RE: AUSTRALIAN MUSEUM - ALTERATIONS AND ADDITIONS  
SSD 9452

On 22 October 2018, the Department of Planning and Environment requested the Government Architect NSW (GANSW) provide an independent design review of the Australian Museum (AM) Alterations and Additions (SSD 9452). In conducting the review, GANSW has considered the EIS prepared by Ethos Urban, dated 4<sup>th</sup> October 2018 (including its appendices), as well as the advice previously provided to the proponent through the State Design Review Panel (SDRP) which is chaired by GANSW.

1 Elevation 01
1:100

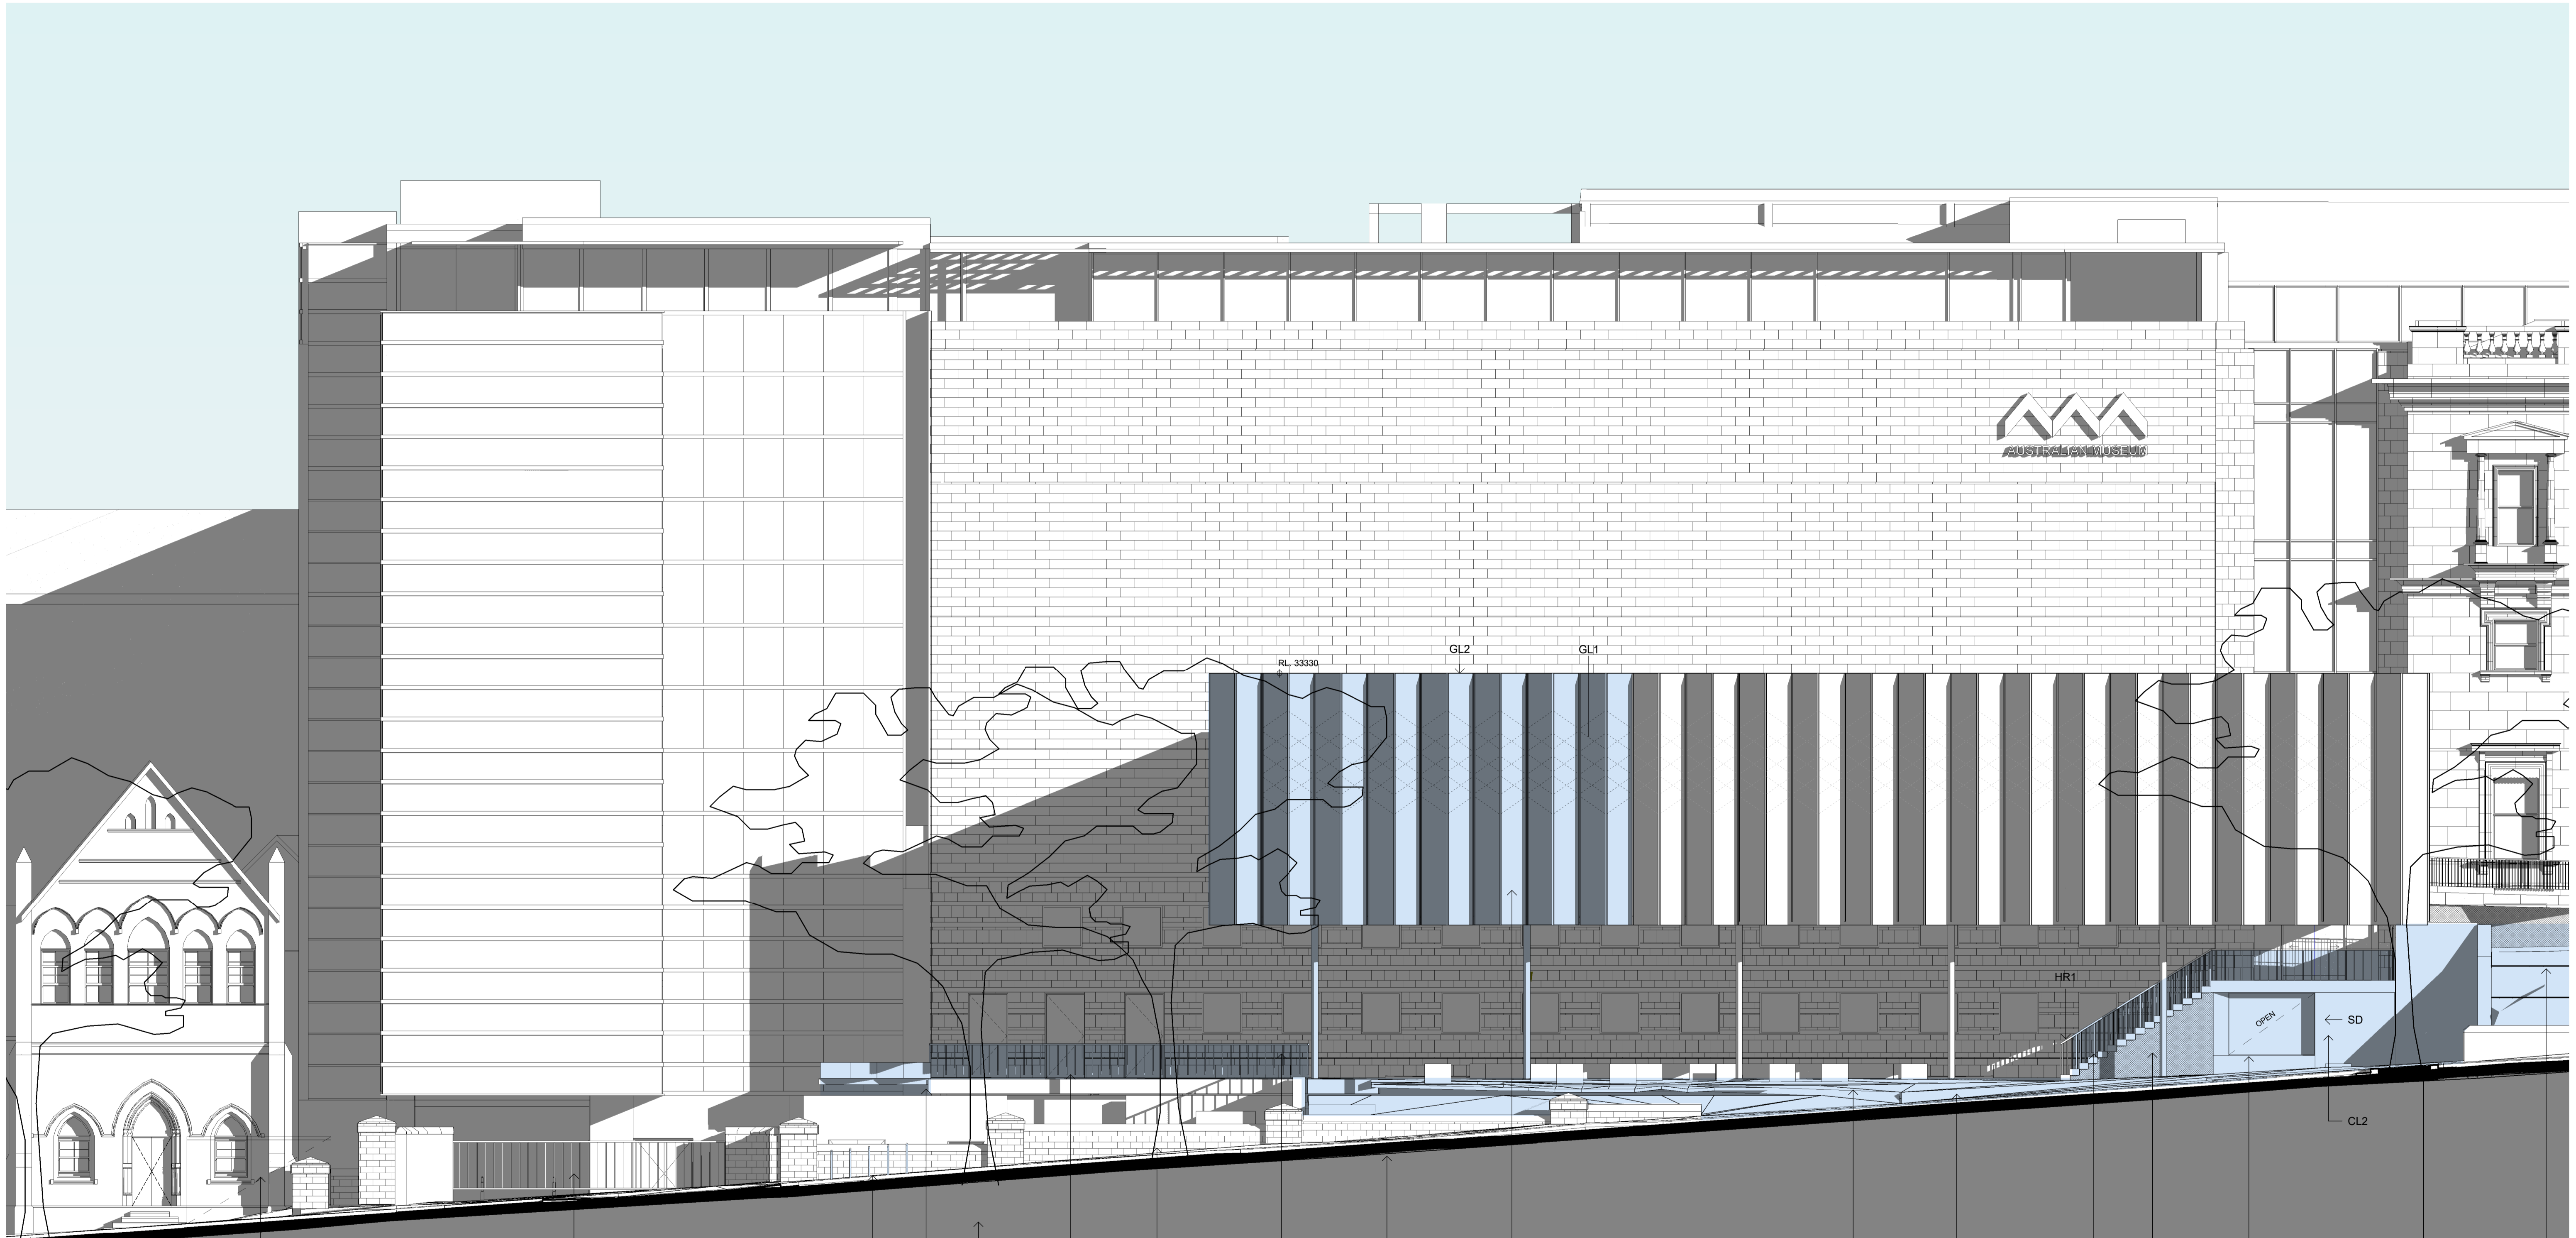
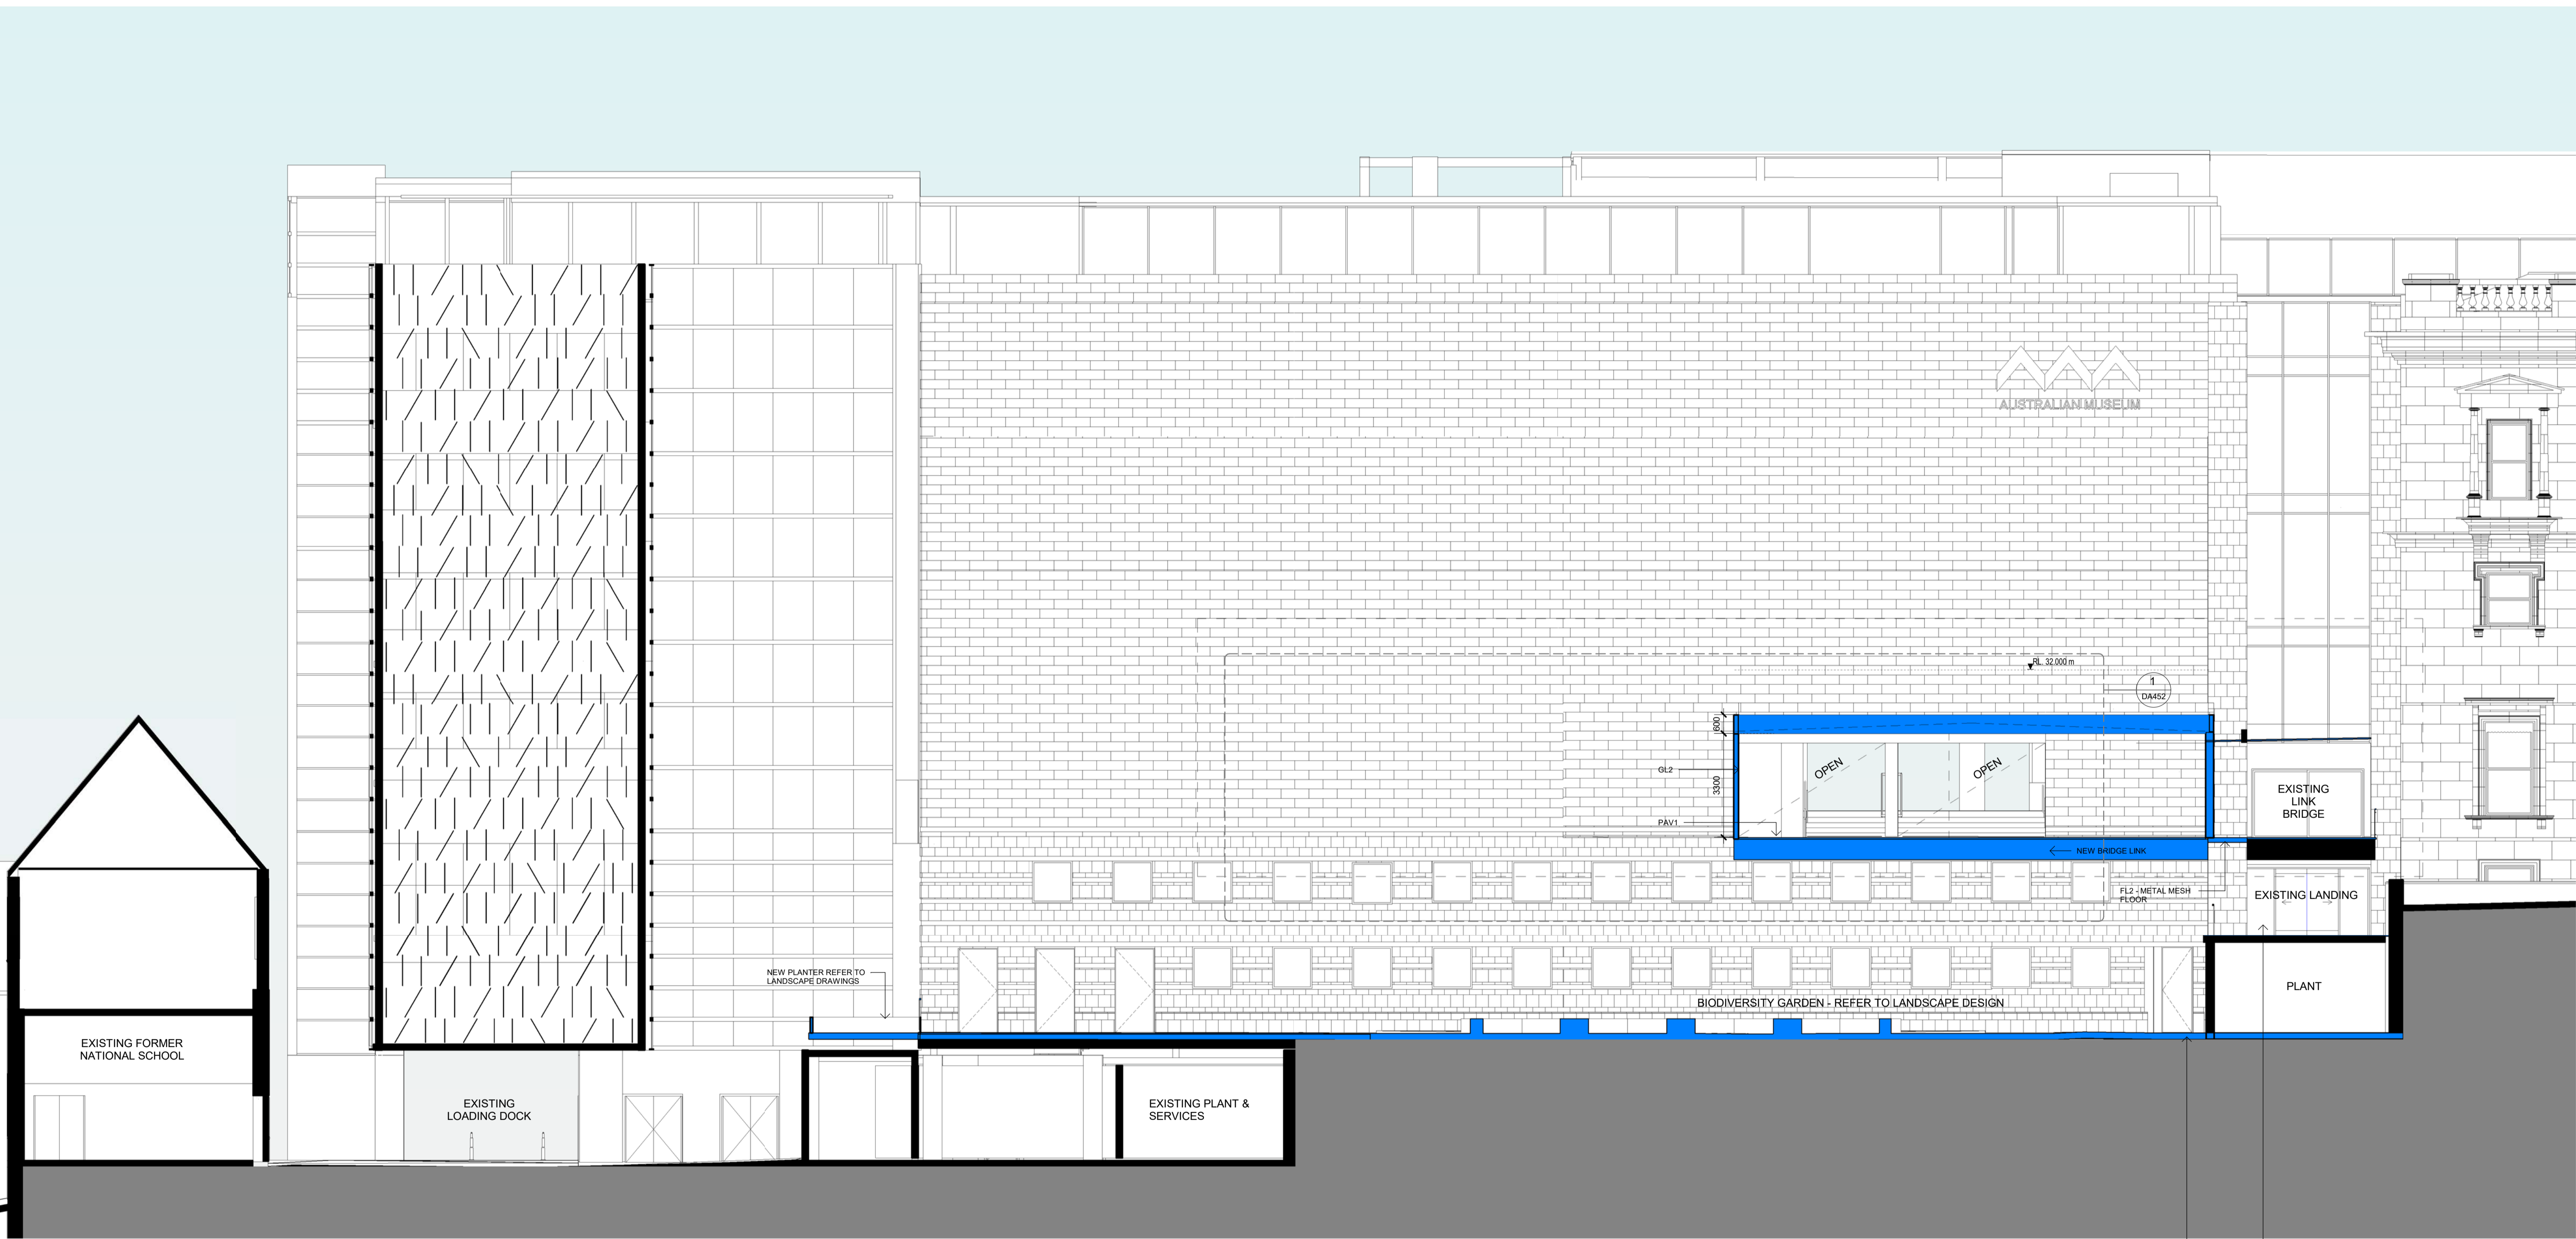
GANSW raises concern that the new secondary groups entry to William Street, compromises the architectural integrity of the Parkes Farmer wing through –

1. the new stair location;
2. the demolition of part of the sandstone façade to create a new door opening, disrupting the regular window pattern.

Given that the progression of Phase 2 works is unconfirmed, the Phase 1 works should be considered as permanent for some time. We are concerned that the configuration and architectural detailing of the new stair structure, will appear as another adhoc and temporary alteration and addition, and will detract from the William Street façade in a similar manner to the Crystal Hall entry ramp, as has been noted by the SDRP panel.

As noted above under Heritage, there is concern that the metal cladding, new external stairs and balustrade details visually detract from the integrity of Parkes Farmer heritage building, as visible from the surrounding public domain.
